**ANNEX 3
COMPLIANCE OF ENVIRONMENTAL STATEMENT WITH EIA REGULATIONS**

BROADWATER ROAD WEST, WELWYN GARDEN CITY
 DETAILED PROPOSALS: ENERGY CENTRE
 PROPOSED GENERAL ARRANGEMENTS
 568_07_165
 SCALE: 1:100 @A0 1:200 @A2

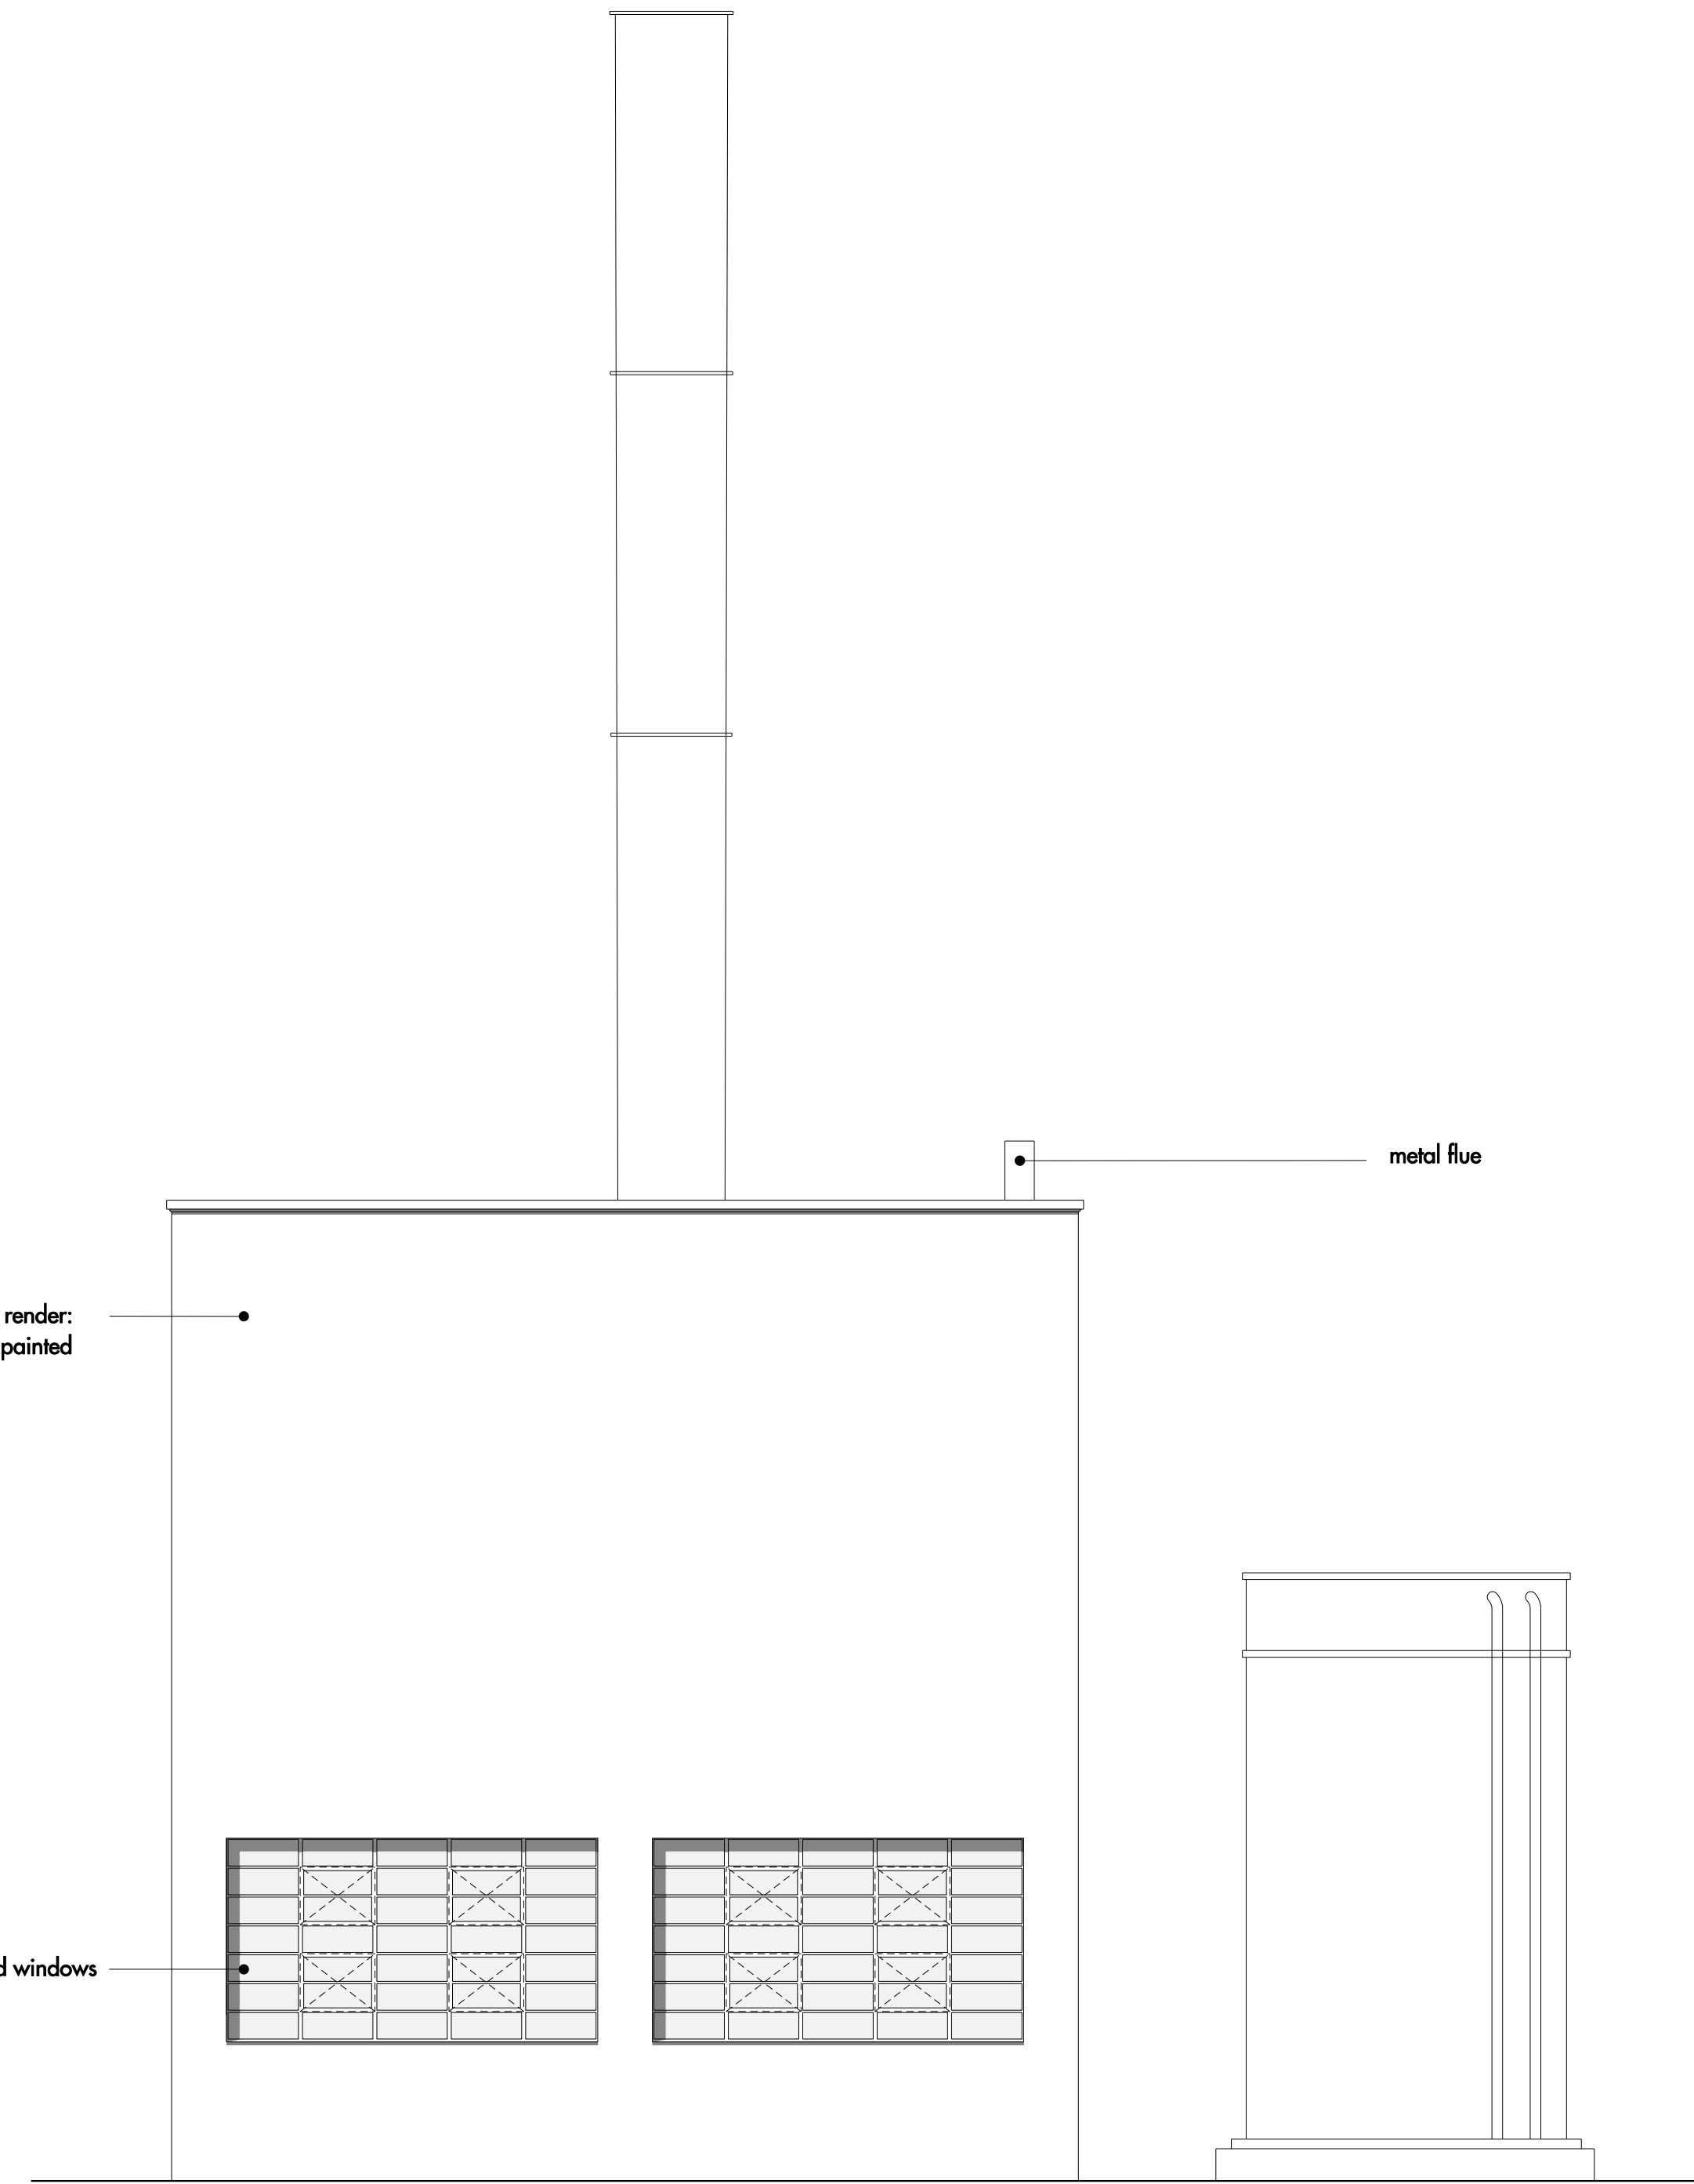
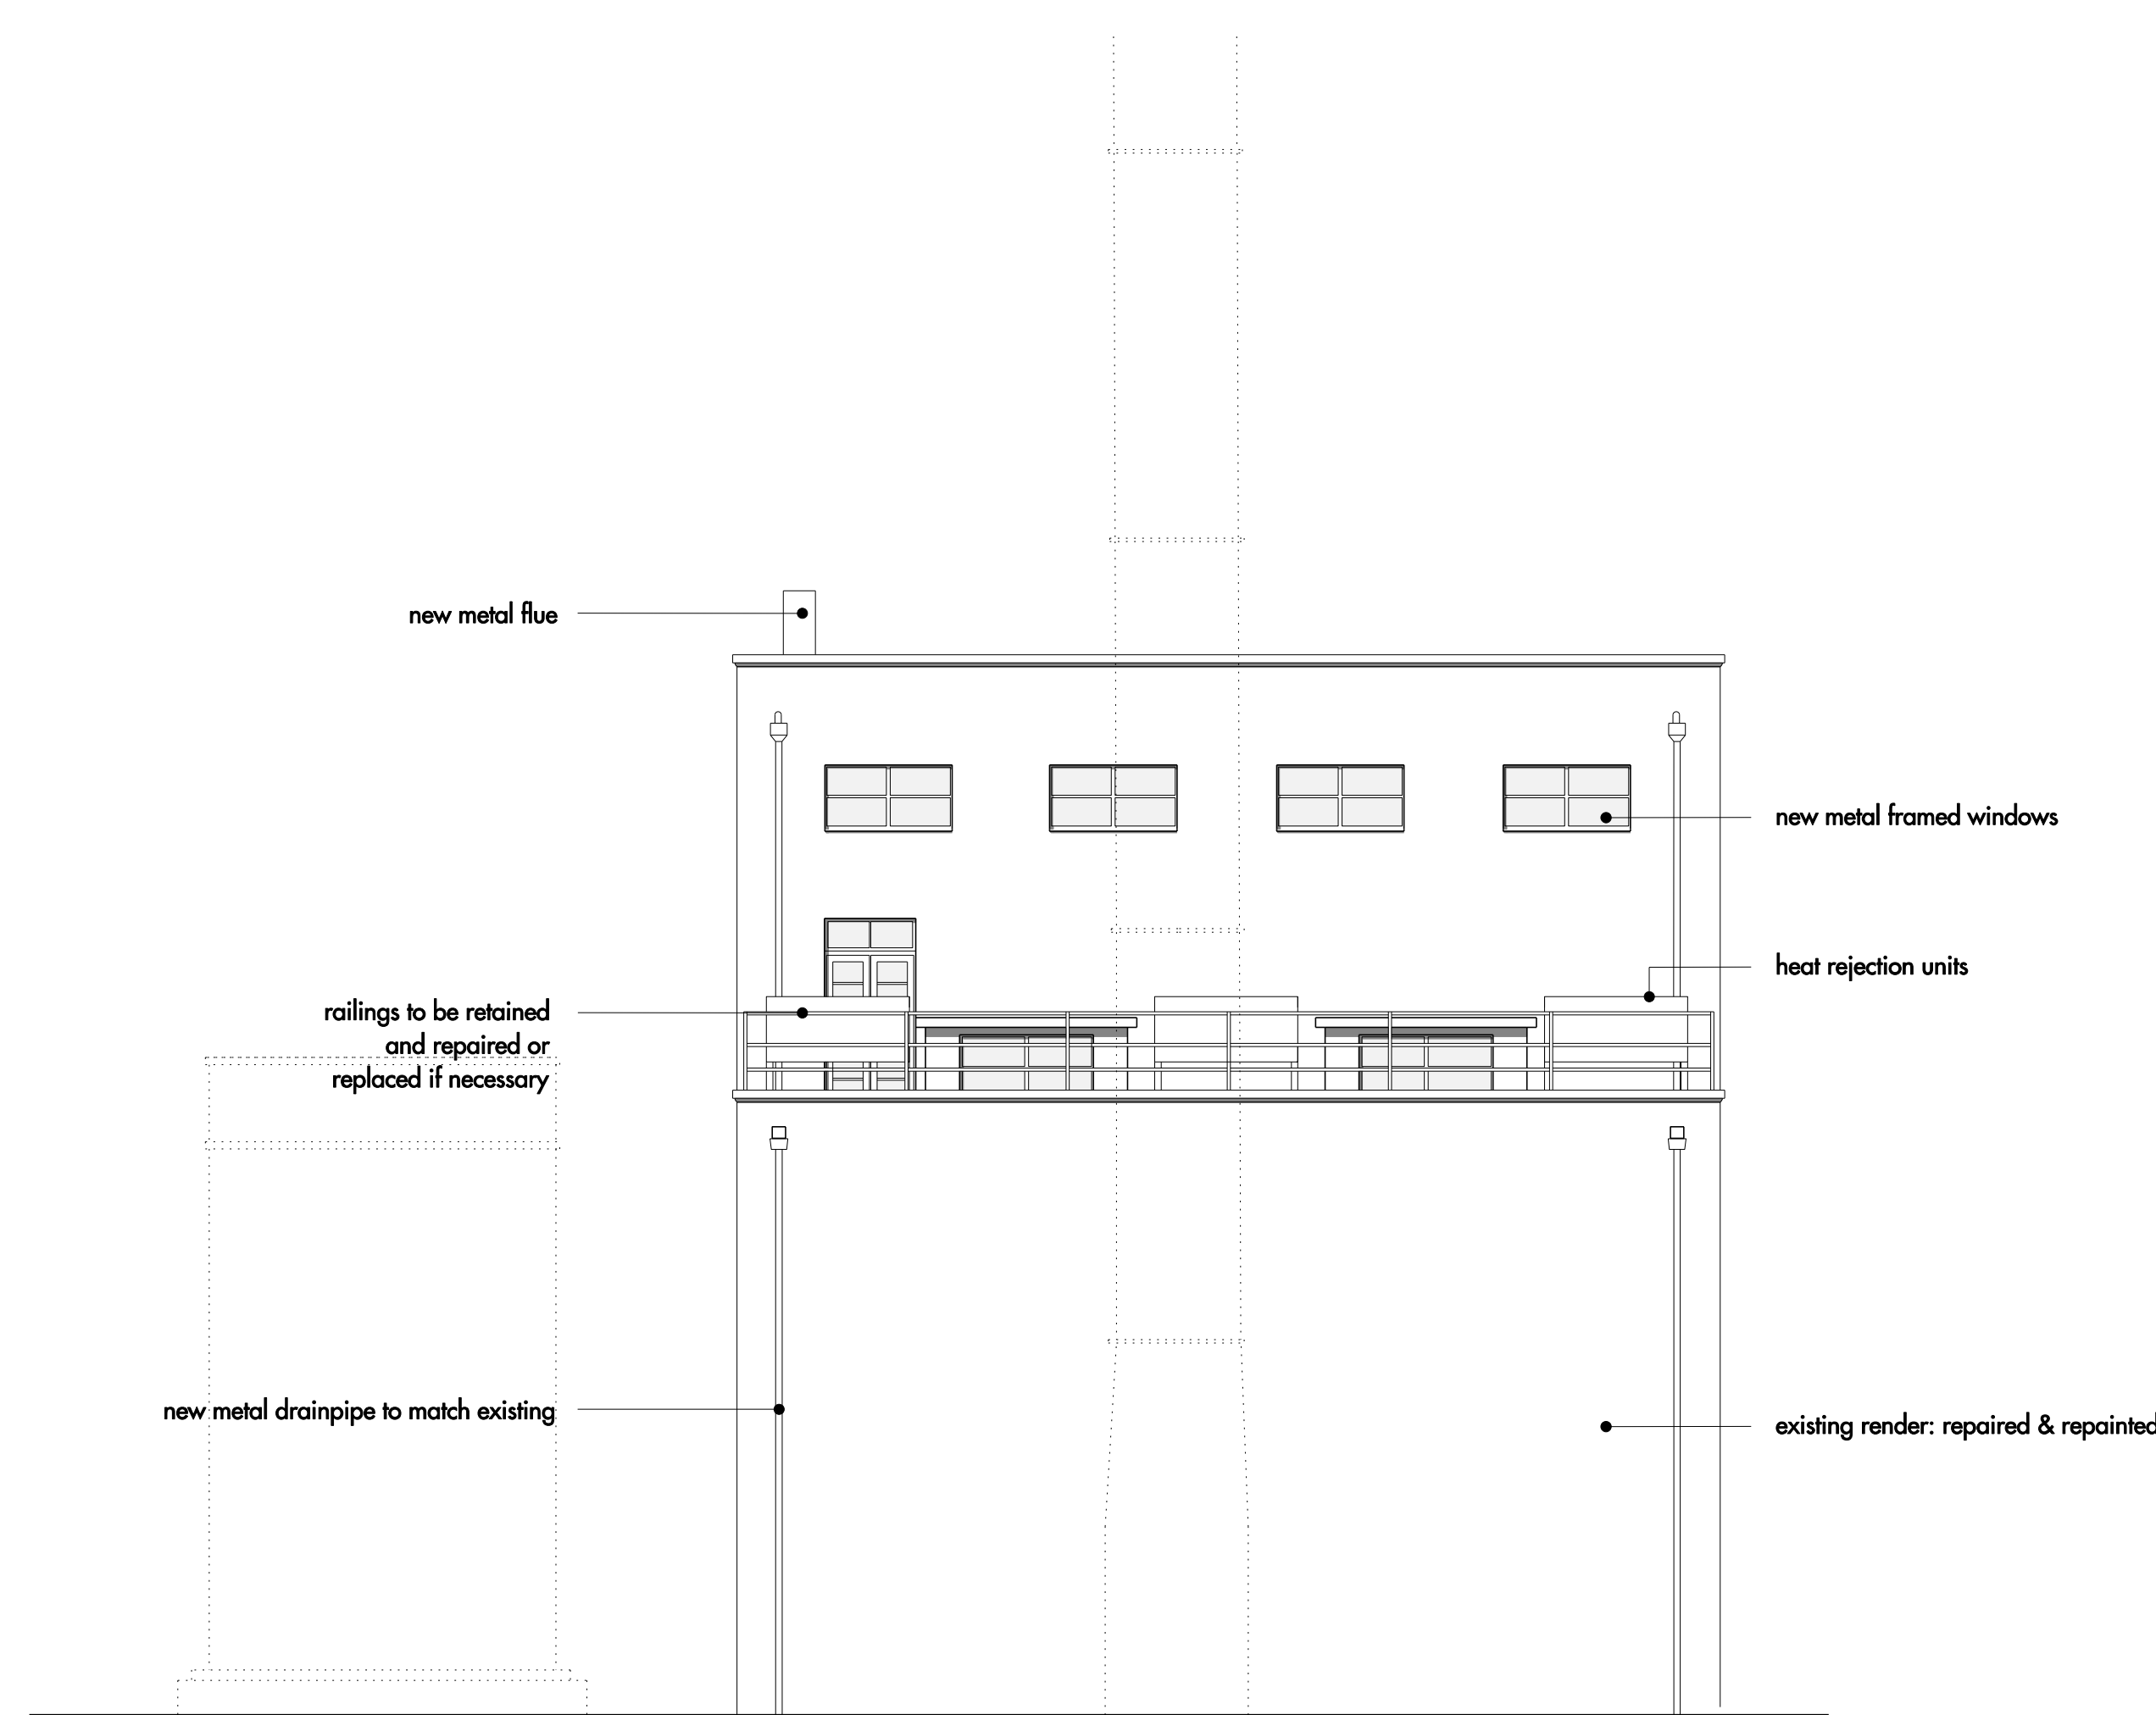
L,C,B,S Ref	ES Ref	Comments	Requirement under ES Regulations	Whether or not complies
		<p>Retained Tree 85 missing from proposals plans.</p> <p>Section 2.1.11 of Part B states that 3 CHP boilers + 3 gas boilers will be accommodated in the Energy Centre, but part C Volume 3 Appendix C seems less certain. Appendix C states that best practice will require individual flues for each of the three proposed CHP boilers, but there does not appear to be enough room for this (Appendix A). A planning condition requiring detailed proposals for flues to be submitted prior to commencement of construction would be appropriate.</p>		
<p>1.1.3 Indication of physical presence / appearance of the development</p>	<p>Section 2 of Part B of ES, and Section 2 of Volume 1 of Addendum. Plans and parameters plans in Part D of ES and Volume 3 of Addendum</p>	<p>Plans are generally clear and easy to reference. Plans and elevations provided for the detailed application area. Parameters plans provided for the outline application area.</p> <p>EIA Part D – Good level of information on general elevations & sections, with further information provided by detailed elevations More information provided by descriptions in Part B Section 2, with additional information in Vol 2 of the Addendum and by the photomontage views and descriptions (Section 5) in Part C Vol 3 Appendix B12 and in the Addendum to the Townscape and Visual Assessment</p>	<p>Not a requirement under the Regulations</p>	<p>B</p>
